From: Sue Howell
Sent: 10 July 2018 14:00
To: Planning.Responses
Cc: Michael Eastham
Subject: RE: Planning Consultation on: CM/13/18/OUT

Comments from Greenspace

Site Address: Land to West of Church Lane South of Horsemere Green Lane
Clymping

Description of Works: Outline application with some matters reserved for the erection of up to 300 dwellings and ancillary development comprising open space, a building within use class D1 of up to 875 square metres net, a building for A1 use having a floor area of up to 530 sq. metres net, together with open space and ancillary works, including access points, car parking and drainage arrangements, with appearance, landscaping, layout; and scale wholly reserved for subsequent approval. The access detail, showing the points of access to the development, and indicated on Bellamy Roberts drawings numbered 4724/013 and 4724/005 Rev A are access proposals to be determined at this stage of the application. For the avoidance of doubt all other access detail within the site is to be determined as a reserved matter at a later stage. Resubmission following CM/1/17/OUT. Departure from the Development Plan.

Appendix A; Figure 1: Proposed Site Masterplan (Source: jrp)

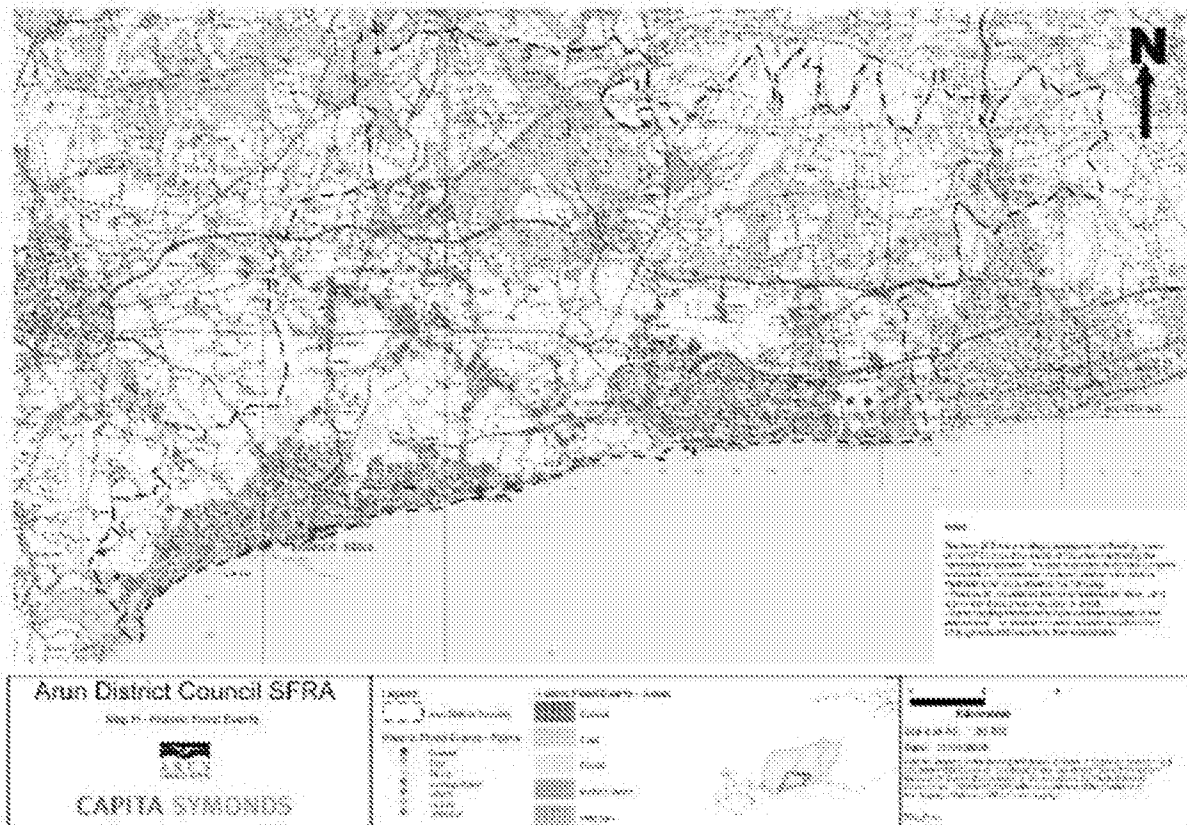
The provision of landscaping for the development must be conditioned with any permission. Some indicative landscape areas have been illustrated with the feasibility illustrative masterplan dwg no p14 4899 01 Rev F. This drawing indicates locations of LAP/LEAP and also where the Open space is proposed. Consideration must be also given to areas of POS where they are also indicated for joint SuDS provision, to ensure that the use of these areas as usable POS is not compromised. Forming part of any application and prior to any consent or condition of any consent, should be the submission for approval of a full landscape scheme, detailing species choice, position, densities and size at time of planting. This should be plotted in plan and list form and in relation to the trees and vegetation to be retained in the locale, so that a clear picture of the proposals can be seen. These details are required to assure the adjacent land setting is maintained, the setting is uncompromised and the proposals are appropriate to its setting also its proximity in relation to the neighbouring South Downs National Park to the North. The long term management of the developing landscape would need to be considered. The landscape scheme should maximise the biodiversity of the site with the inclusion of native species and the retention of a variety of habitats.
